Westmead Catholic Community Education Campus (SSD-10383)
Response to Submissions

ATTACHMENT 1 – KEY ISSUES

OPEN SPACE - GROUND FLOOR,
OVAL AND LEVEL 01
sheet

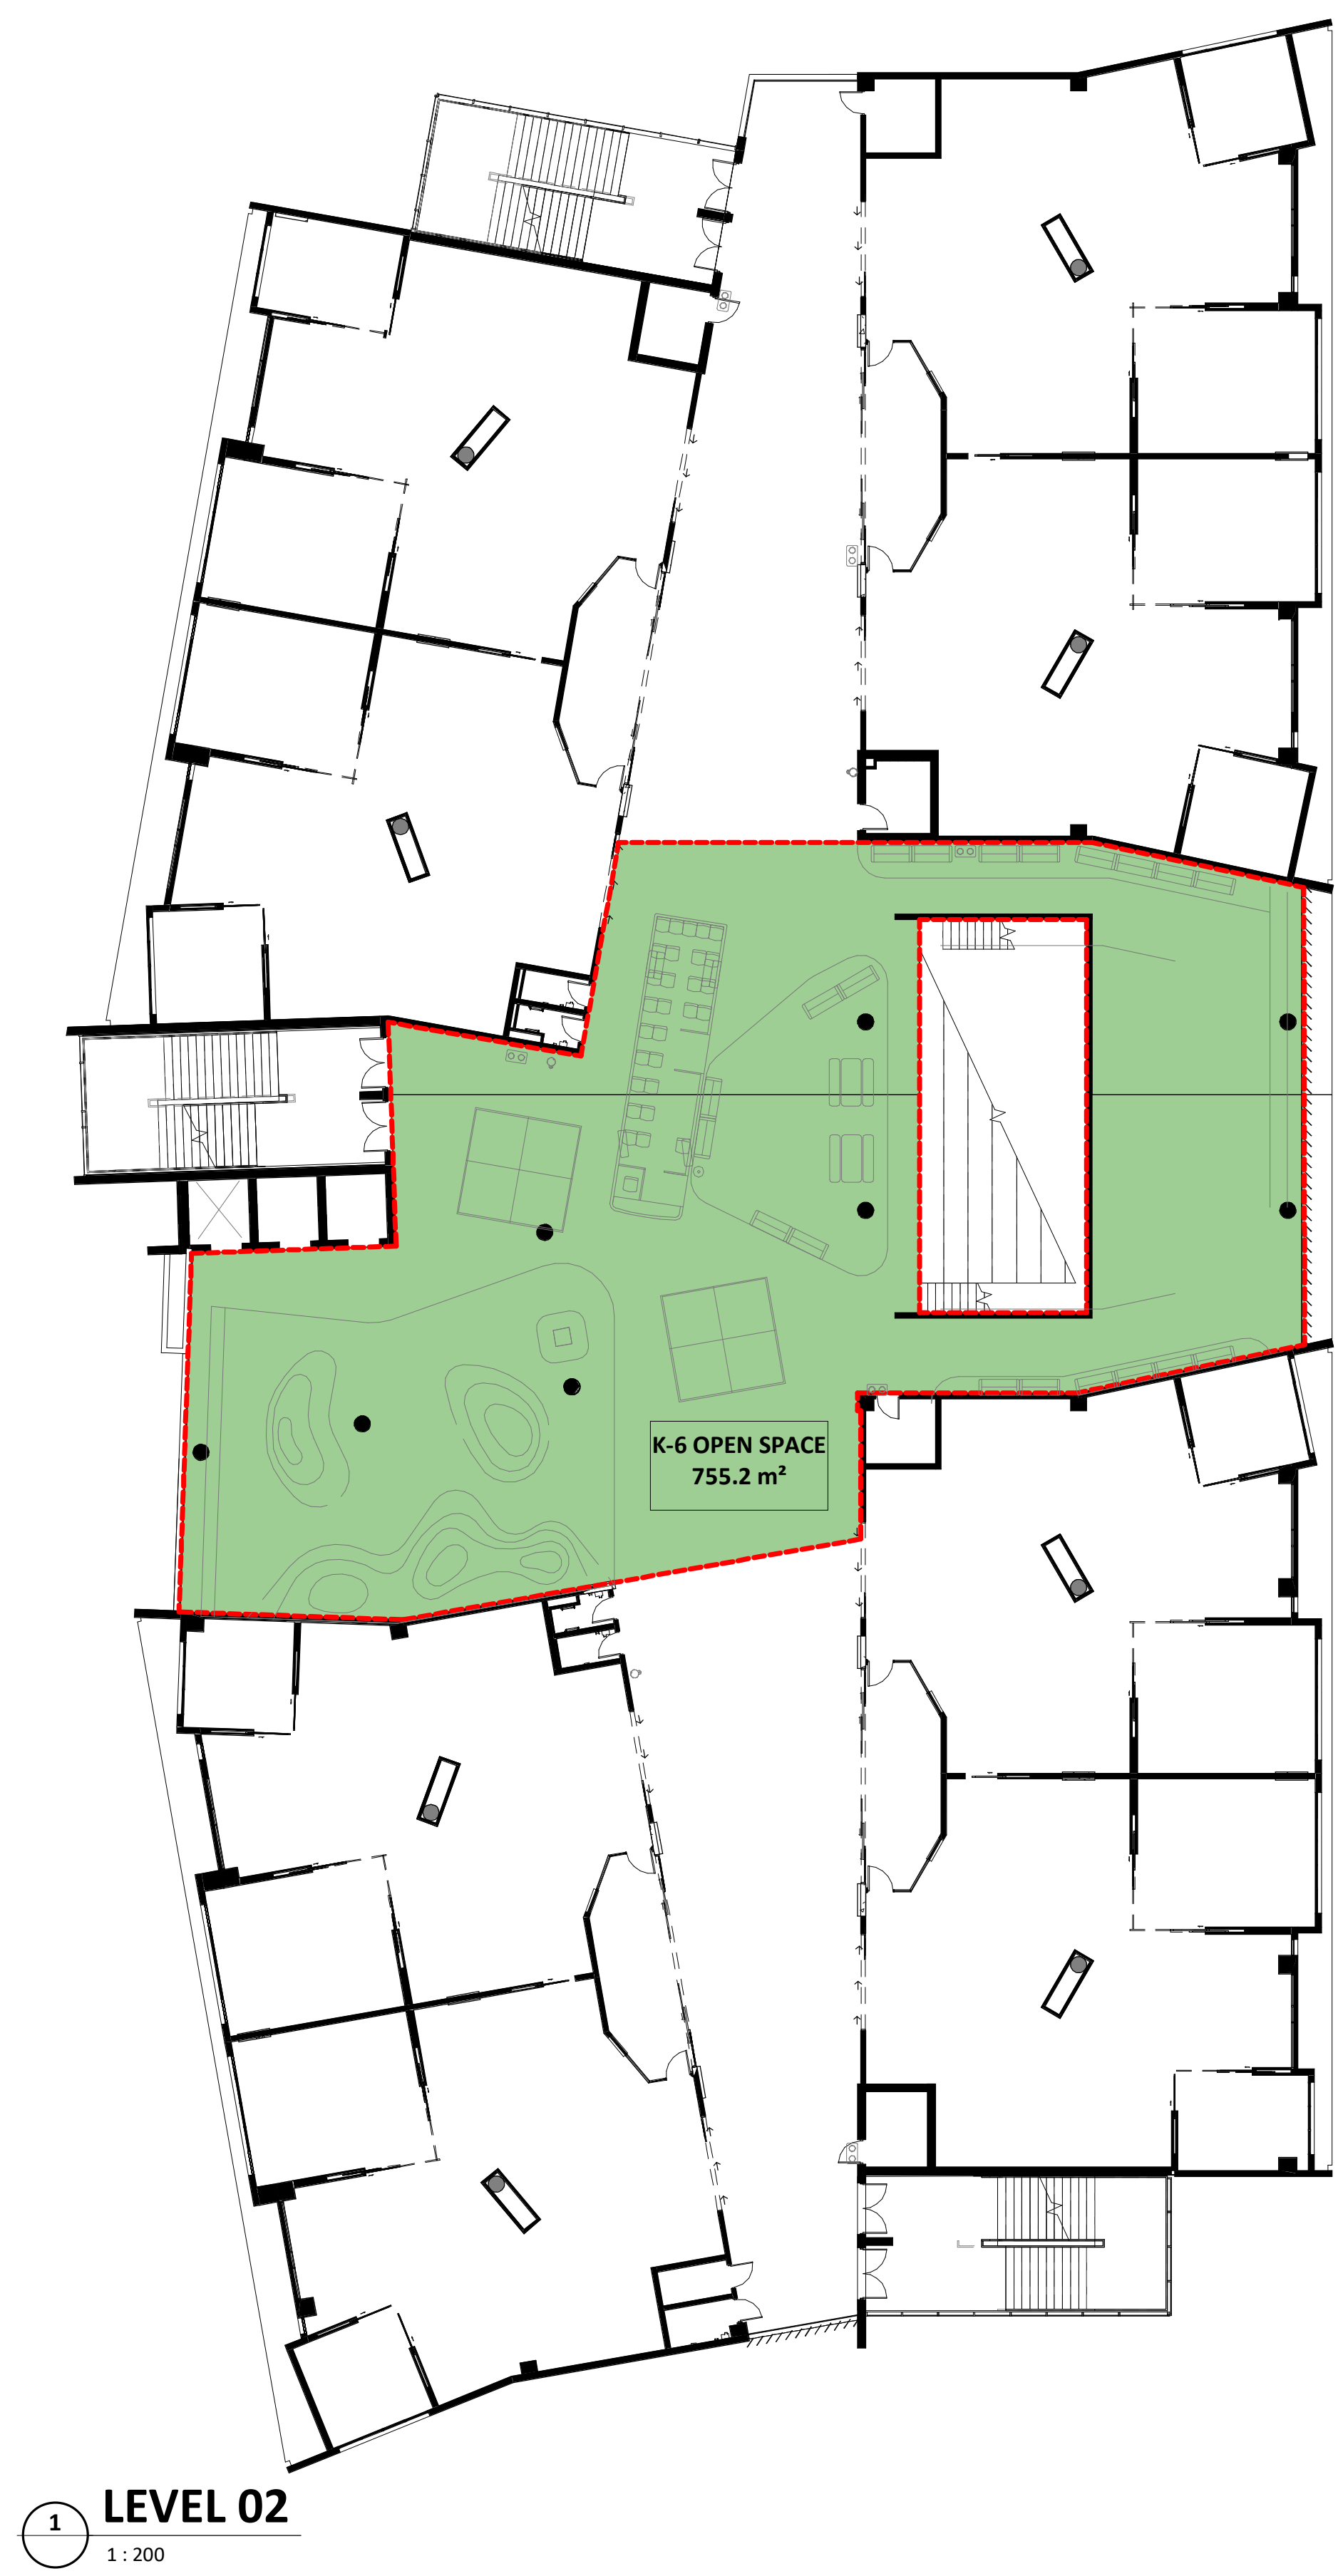
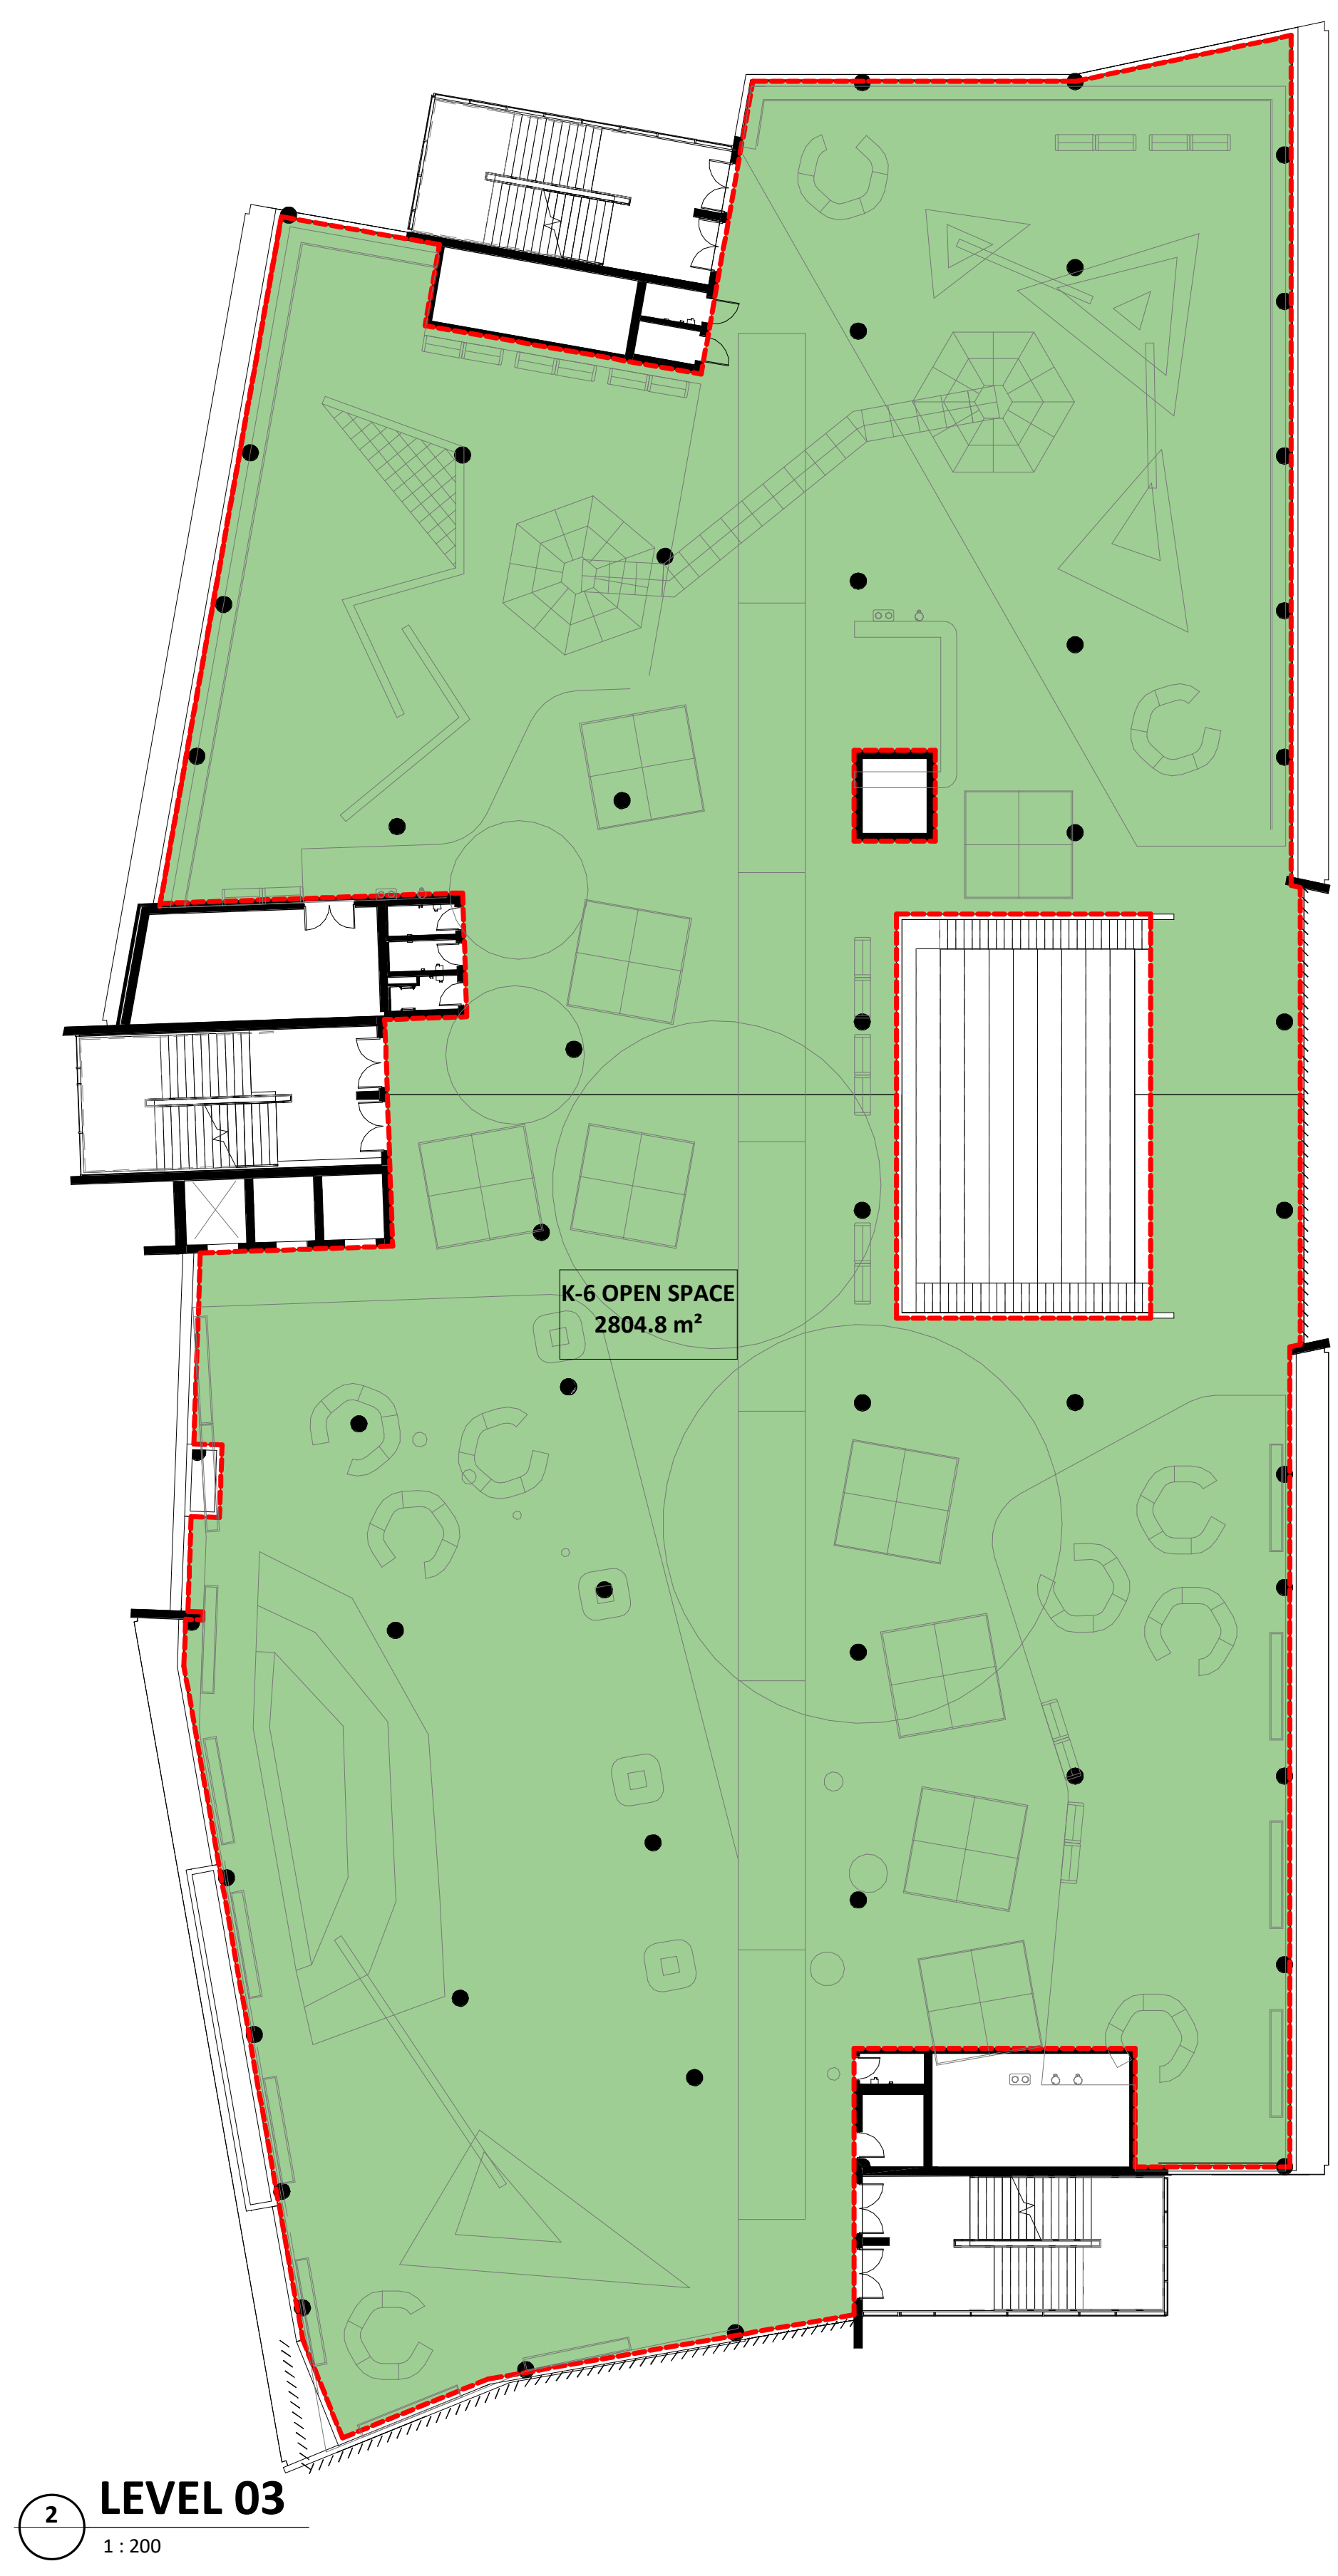
- the open space diagrams indicate that circulation areas in between classrooms have been added as open spaces. The circulation areas should be deleted from the calculation of open space areas.
